Date: 08 March 2019
Our ref: 273190
Your ref: TR020002

NSIP Reference Name / Code: Manston Airport / TR020002
Natural England's submission for Deadline 4: comments on the Applicant's responses to the ExA's 1st written questions

Title **LOCATION PLAN REGULATION 5(2)(j) THANET DISTRICT COUNCIL**

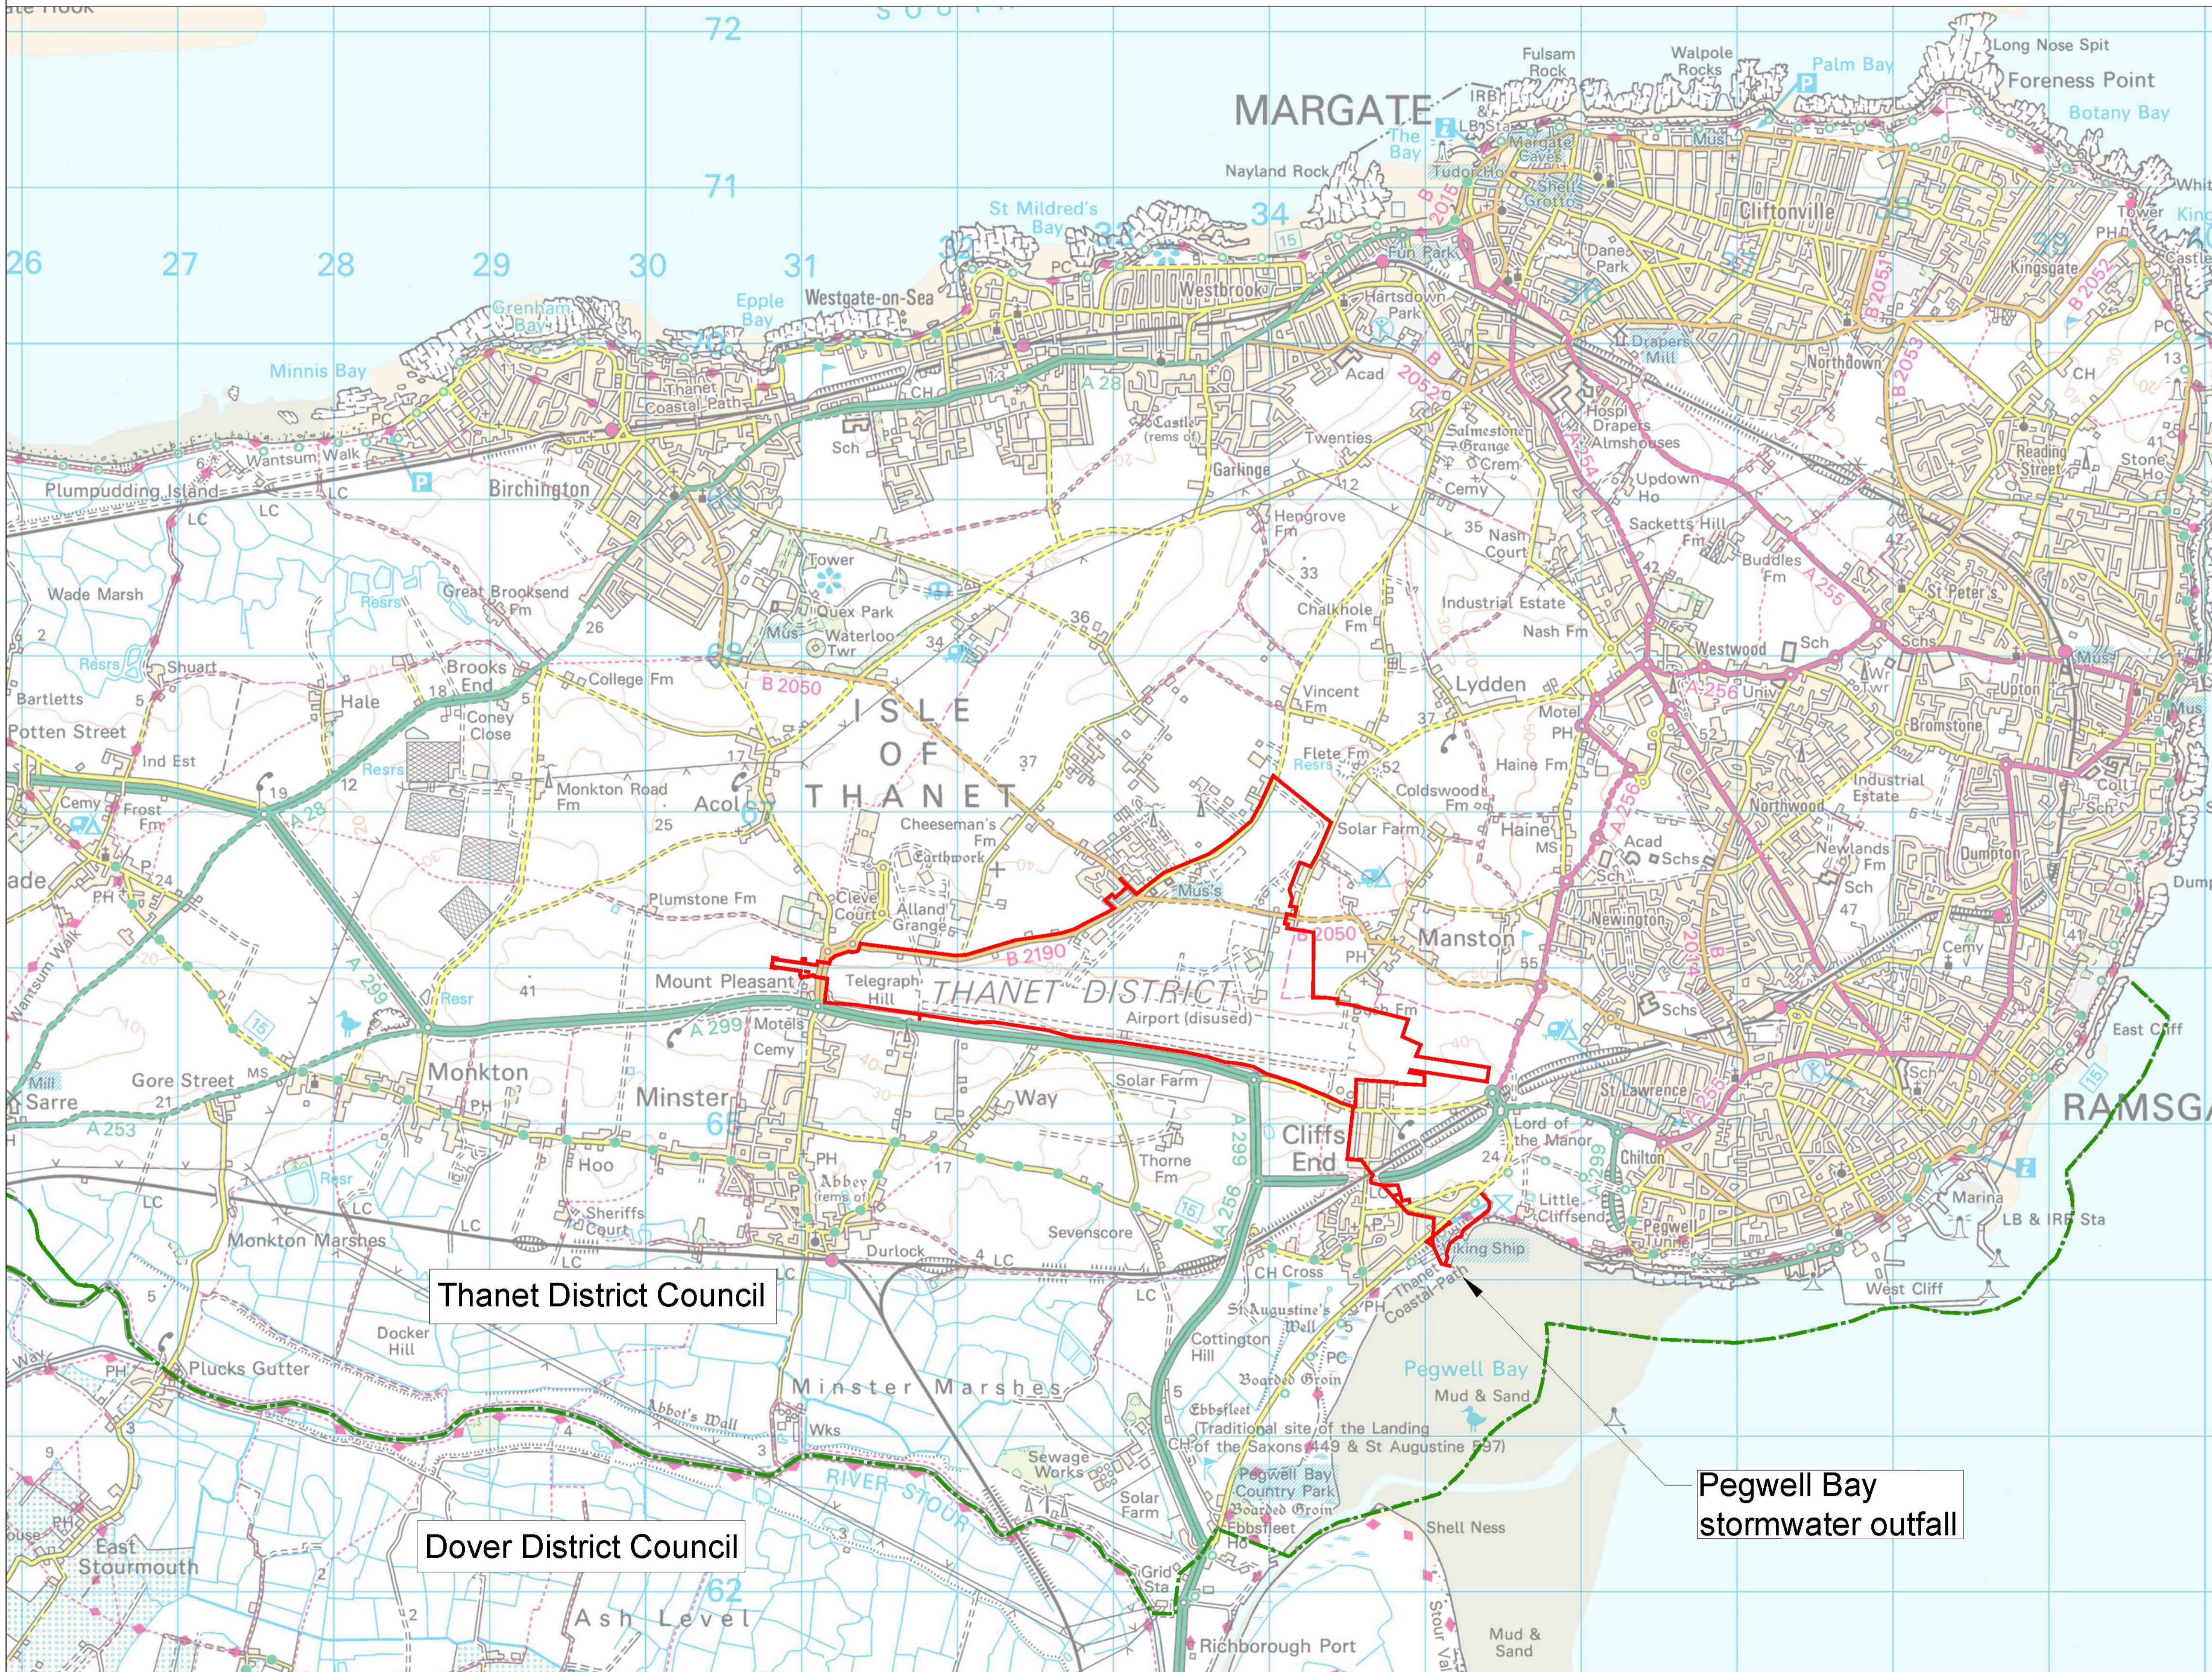
- i) Natural England notes that the Environment Agency, in their response to the ExA's first questions, has confirmed that as the Applicant plans to discharge clean, uncontaminated effluent via an existing surface water outfall, then no permit or authorisation is required. This is helpful clarification, however Natural England advises that certainty is required for the HRA that the surface water will be uncontaminated.

Our view is that in principle, Sustainable Drainage Systems (SuDS) are an appropriate way of avoiding pollutants entering sensitive designated sites. However, Natural England recommends using the risk-mitigation index approach in the CIRIA SuDS Manual to demonstrate that the SuDS proposed is sufficient. Furthermore, clarity is required over the additional measures required to address the specific pollutants arising from the runway and aprons. Monitoring will also be required, with emergency measures incorporated, to ensure that contaminated water does not enter the designated site.

- ii) The list of sites and habitats provided by the Applicant, and the reference to the photographs of the outfall in Appendix 7.8 of the ES [APP-046] are helpful. Natural England is satisfied that this resolves our request for confirmation of the habitats and species potentially affected by the outfall.

- iii) The list of works required to repair and refurbish the outfall is helpful. From the list of works presented, it does not appear that there will be any direct loss of the designated sites as a result of the works. This resolves Natural England's concern (set out in paragraph 3.3.6 of our written representation) that the scour protection and channel works at the outfall may impact the designated sites. The only remaining potential issue is the method by which the repair works will be carried out. The Applicant's answer to Ec.1.7 states that the works could be carried out by 2-3 man teams with maintenance vehicles. These vehicles should avoid the mudflat if at all possible. If it is unavoidable, mitigation measures will be needed, such as the use of bog mats, to avoid compaction of the mudflat. Furthermore, the works should be

timed outside the wintering period to avoid disturbance to the bird interest of the designated sites. It is not clear whether the maintenance work would be covered by the DCO, but if not it may need a separate SSSI consent from Natural England.
